Sizewell C (SZC)

Planning Inspectorate Reference: *EN010012*

Deadline 7 – 3 September 2021

East Suffolk Council's (20026200) Response to Examining Authority's Second Round
of Written Questions

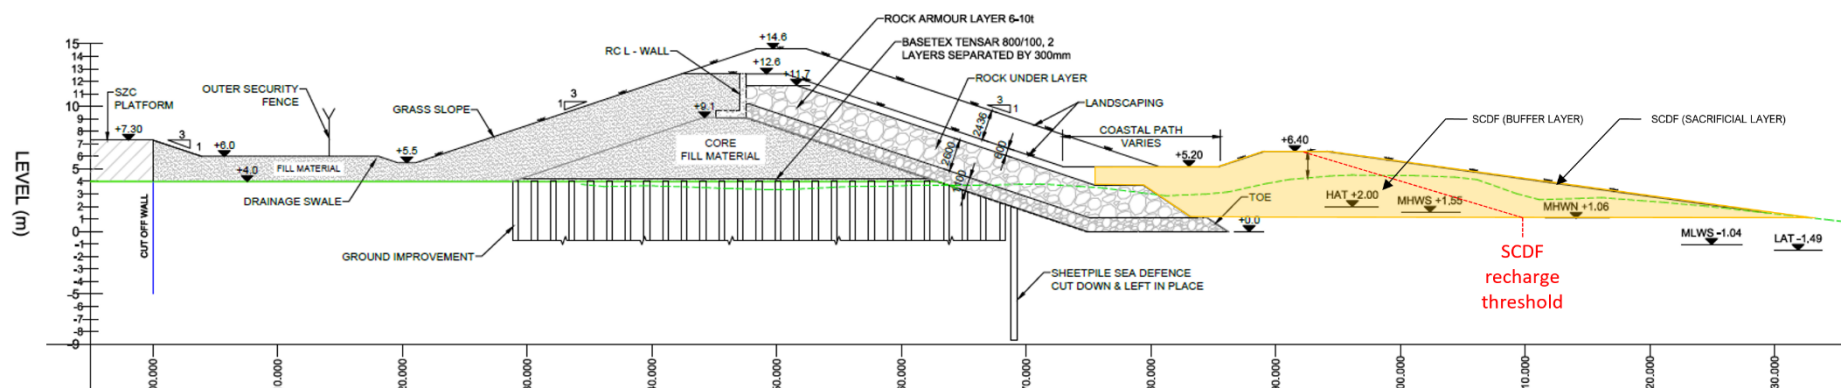
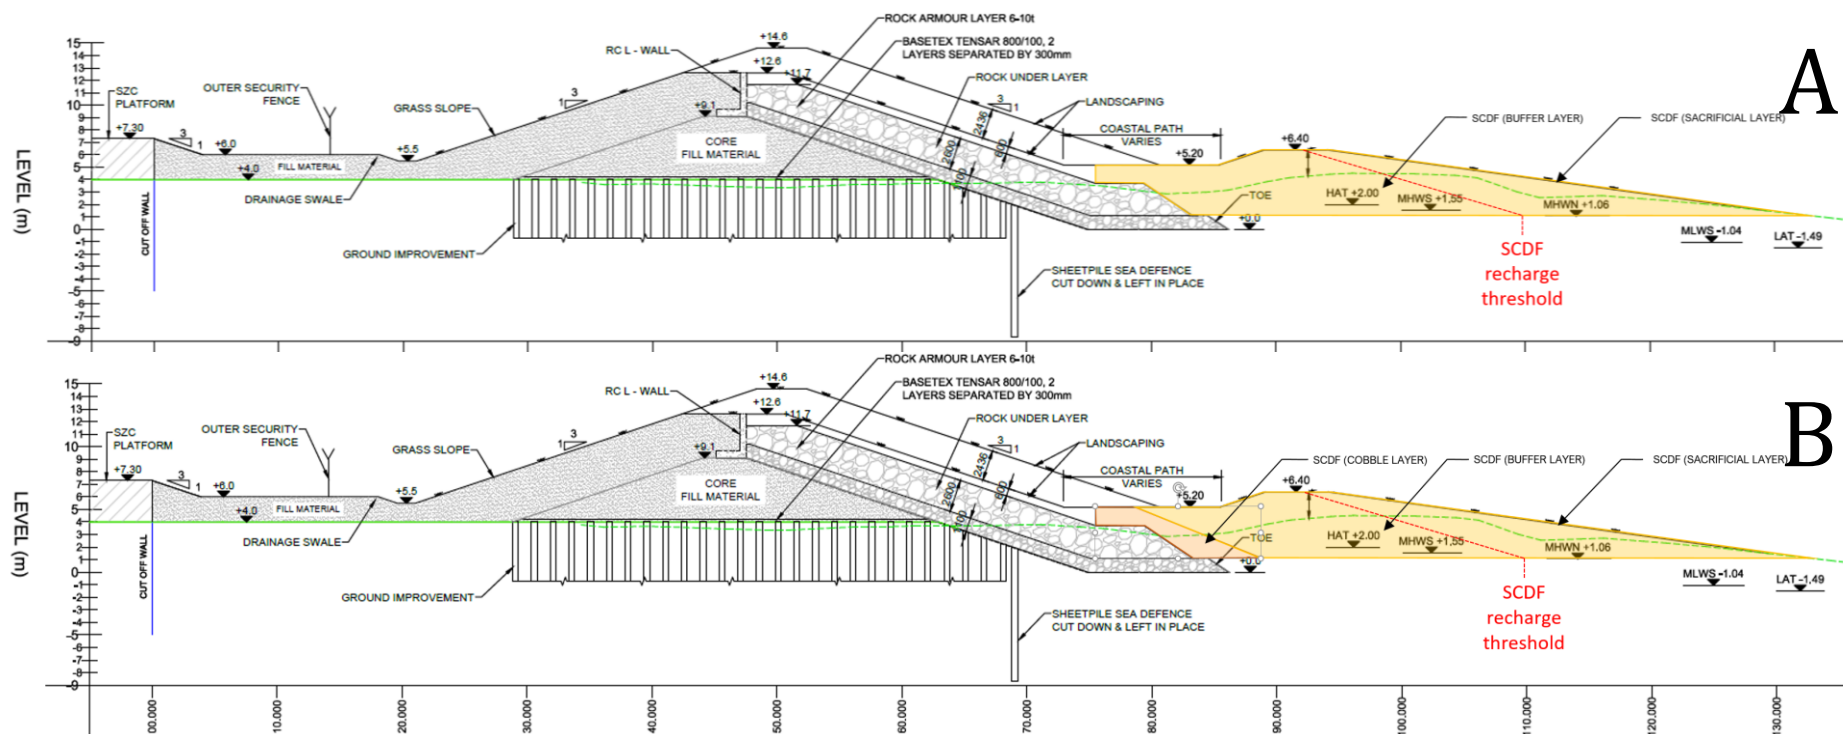
CG.2.4	ESC	<p>Impacts on coastal processes</p> <p>The ESC's DL5 written summary of oral submissions at ISH6 [REP5-144], in relation to Item 3b states that in the light of SMP Policy 13.1, the Applicant should minimise the seaward extent of the coastal defence features as far as possible. The Applicant's DL5 submissions include further details of the reduced seaward extent of the coastal defences at Appendix A to the Applicant's written submissions responding to actions arising from ISH6 and Revision 2 of the Coastal Defence Features Plans [REP5-118].</p> <p>(i) In the light of the additional information and plans provided by the Applicant at DL5, are you satisfied that the HCDF is located as landward as possible?</p> <p>(ii) If not, please explain whether and, if so, why any further changes to the seaward extent of the coastal defences are sought?</p>	<p>(i) The recently retreated position of the HCDF is welcomed but it remains significantly further seaward of the defence line established by Sizewell A and B. It may also extend further seaward if an adaptive profile is required by future flood risk assessments. Further changes are sought because, in ESC's view, the Applicant has not provided sufficient evidence to demonstrate that variants on the HCDF design have been explored with a view to minimising the seaward footprint. A particular case in question is described below. Notwithstanding this, ESC accepts that the MDS footprint must not encroach upon the SSSI to landward of proposed development.</p> <p>(ii) Refer to (i). A further landward position of the HCDF may be achievable through a different design of the HCDF armour system which uses concrete armour units instead of large armour stones. If proved viable, the use of concrete units would enable (possibly necessitating) a steeper slope at the armour face. A steepening in armour slope could yield a significant saving on the footprint, equal to the slope difference multiplied by the vertical height of the slope.</p> <p>For concrete armour units, the beach regain would be reduced marginally due to a small increase in the crest elevation needed to limit overtopping, but the net result should still be a saving on beach coverage.</p> <p>The Applicant's Design Report (9.13 Sizewell C Coastal Defences Design Report) [REP2-116] lists, in</p>

<p>qualitative terms, reasons why not to use a steeper slope / concrete armour, but these reasons are not substantiated or demonstrated formally.</p> <p>ESC seeks the provision of quantified information to demonstrate the merits of rock armour (at 1:3 slope) versus the use of concrete armour units (at a steeper slope), subject to both meeting the same required design standards.</p>
CG.2.5	MMO, ESC, EA, MMO	<p>Impacts on coastal processes</p> <p>The Applicant's DL5 written submissions responding to actions arising from ISH6 Appendix A para 1.2.4 [REP5-118] refers to four additional terrestrial piles (above Mean High Water Spring) are required to support the two additional removable deck spans for the permanent BLF that are required now that the HCDF does not extend as far seaward as it did previously. Are there any concerns relating to the provision of these additional piles?</p>	<p>A modelling assessment is due from CEFAS to evaluate the potential for scour around these piles. ESC awaits the results of the EIA on beach receptor. ESC PRoW may dispute extra piles for decreased beach access and amenity value.</p>
